KITTITAS COUNTY

MEMORANDUM

TO: All Staff
FROM: Public Works Plan Review Team
DATE: December 1, 2023, at 5pm
SUBJECT: SP-23-00010 NH2G

SHEET 1 OF 3

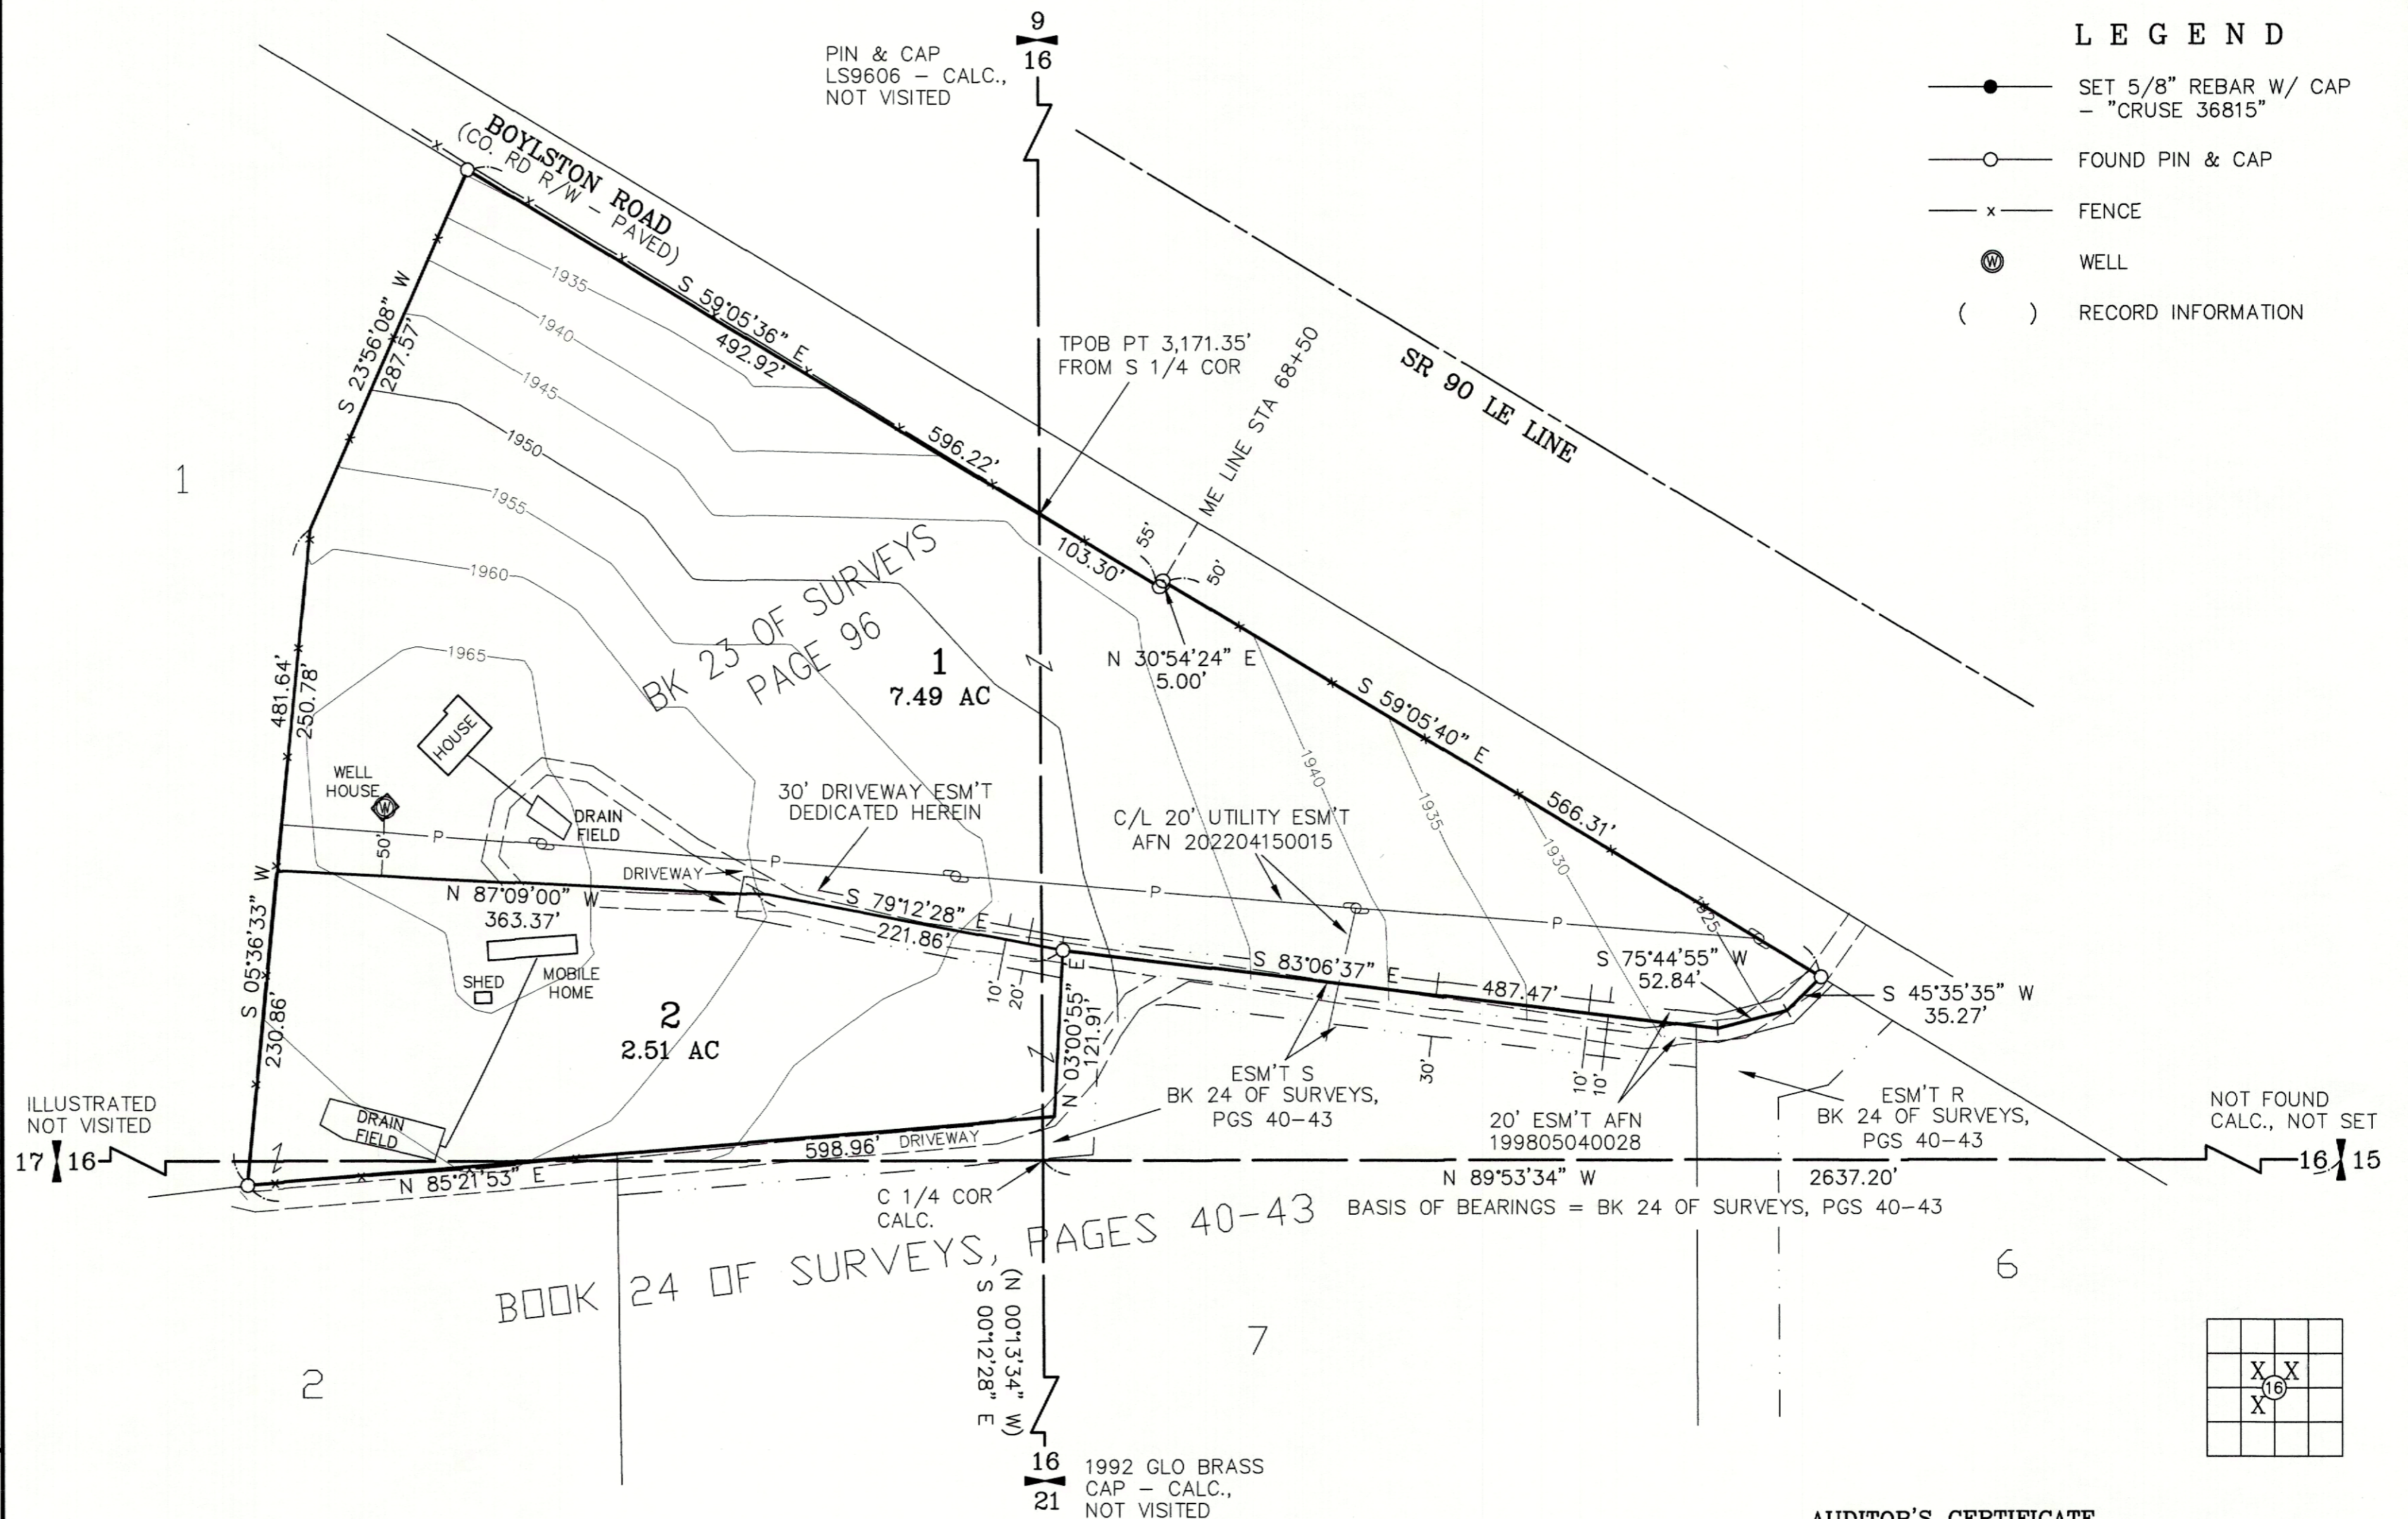
SURVEY	<p>No changes required for the Preliminary Short Plat.</p> <p>The following comments are in regards to the final submittal:</p> <ol style="list-style-type: none"> 1. At minimum the new boundary line will need to be staked in the field, and corners shown on the face of the map. 2. The driveway easement dedicated hereon will need to contain enough information to be mathematically retraceable. 3. Lot closures will need to be provided. (JT)
TRANSPORTATION CONCURRENCY	No transportation concurrency required at this time. (KH)
FLOOD	Parcel #330733 is not located in the FEMA identified special flood hazard area (100-year floodplain). (SC)
WATER MITIGATION/ METERING	The proposed lots each have an existing house that share a well with a permit exempt use that was established prior to 2014. No additional water mitigation or metering requirements are applicable to the short plat as proposed. (SC)
